Online Comment

Application H13-0683-16
Location off Pipwell Gate Moulton Seas End Spalding PE12 6LU
Proposal Residential development (single building plot)

Name J Reith
Address Environmental Health Technician Safety and Environment

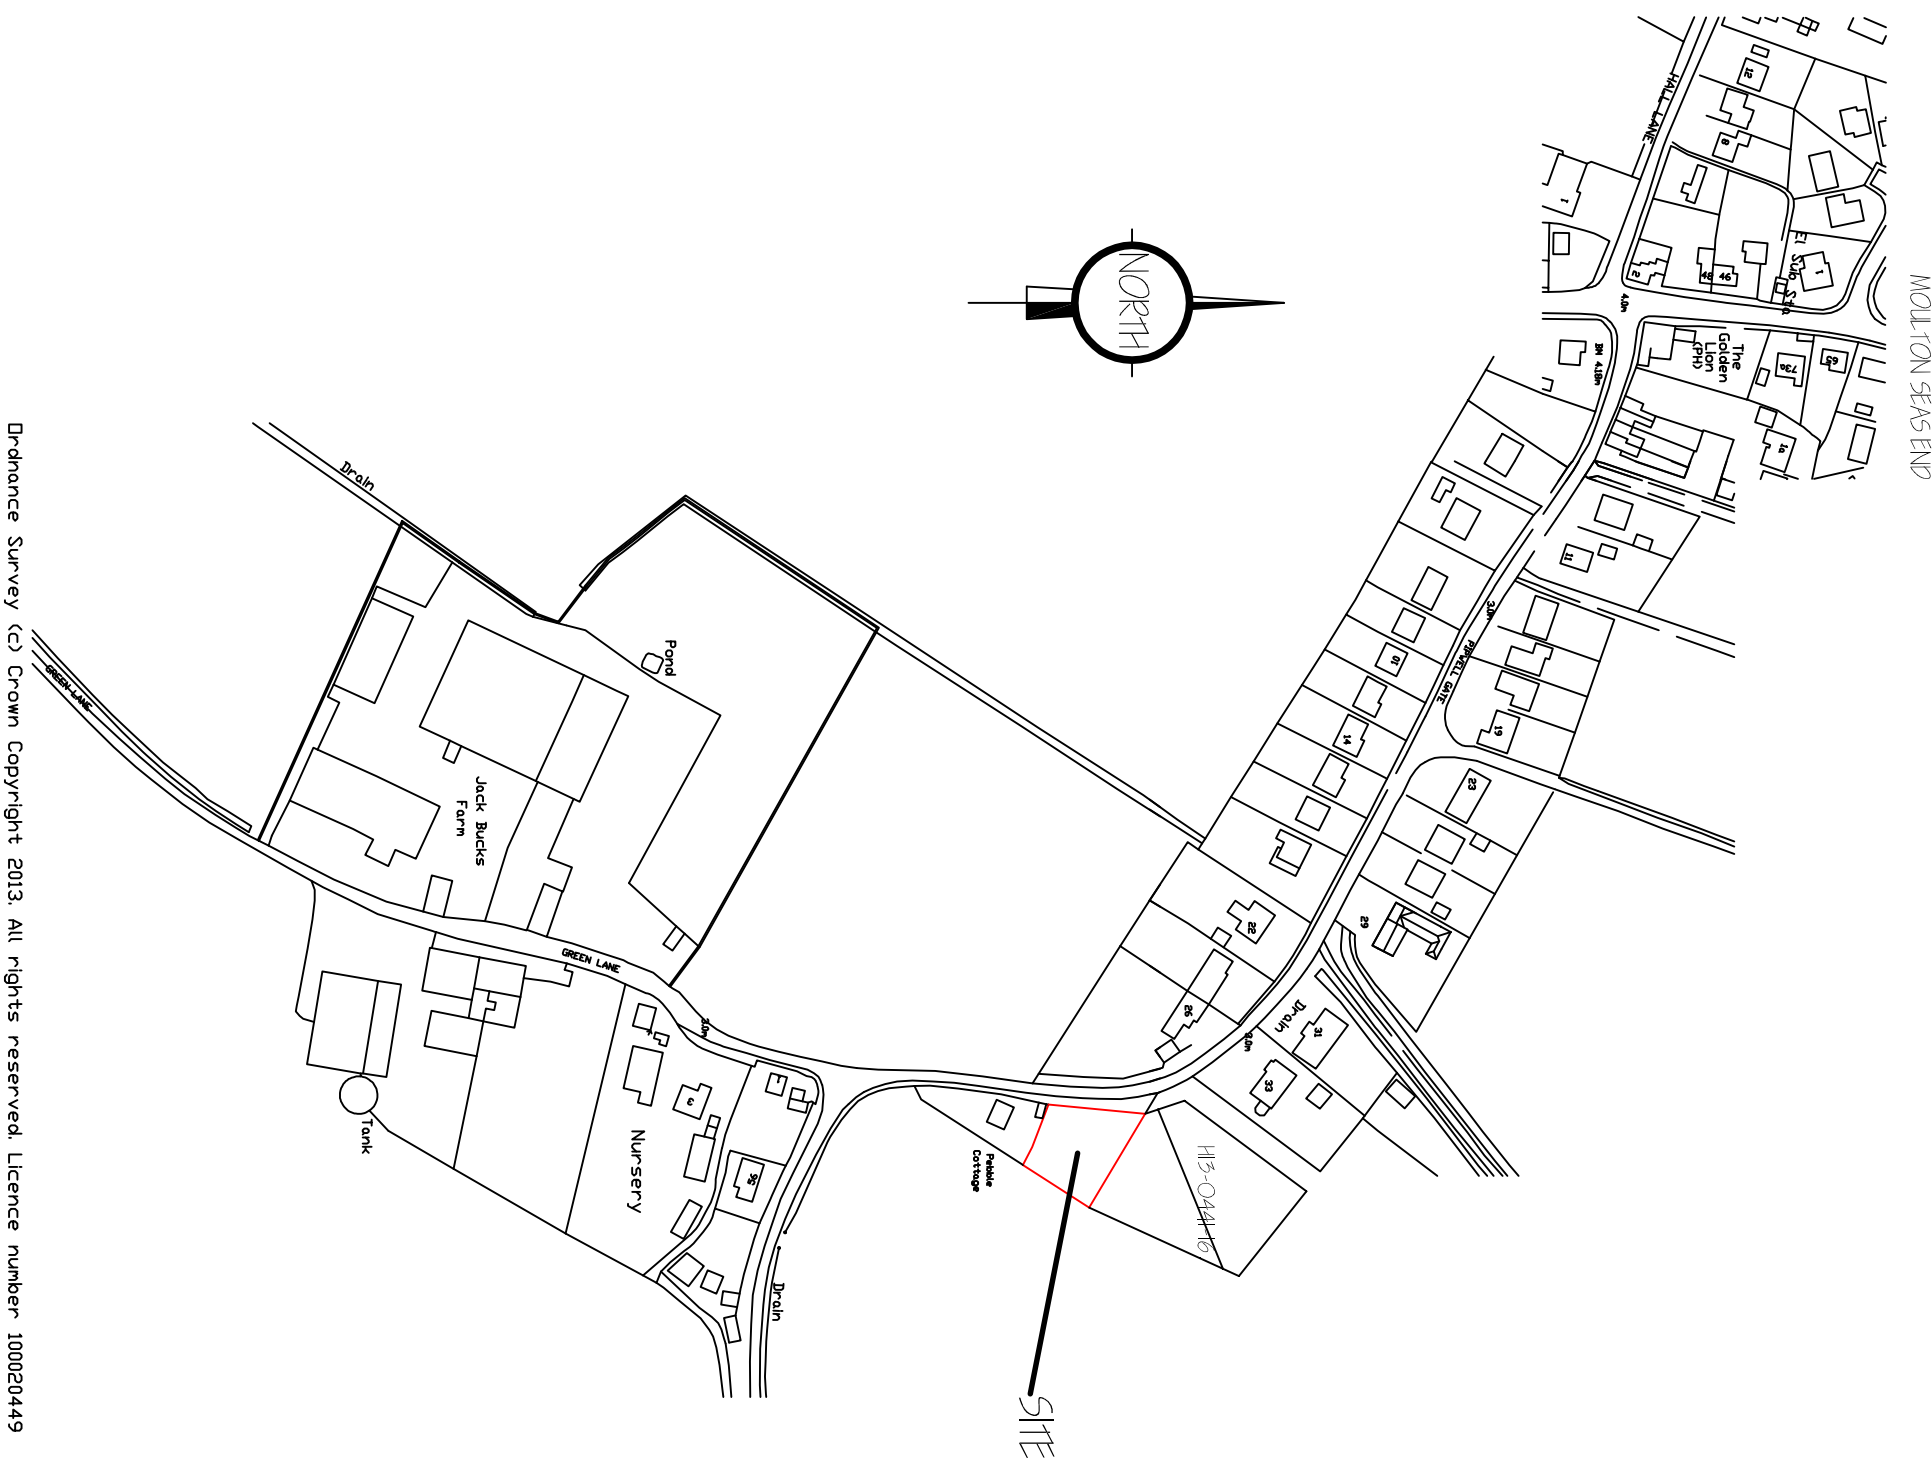
Further to comments received by a member of the public I request the contaminated land condition for this application in order to ascertain whether there is asbestos buried on site. Thanks.
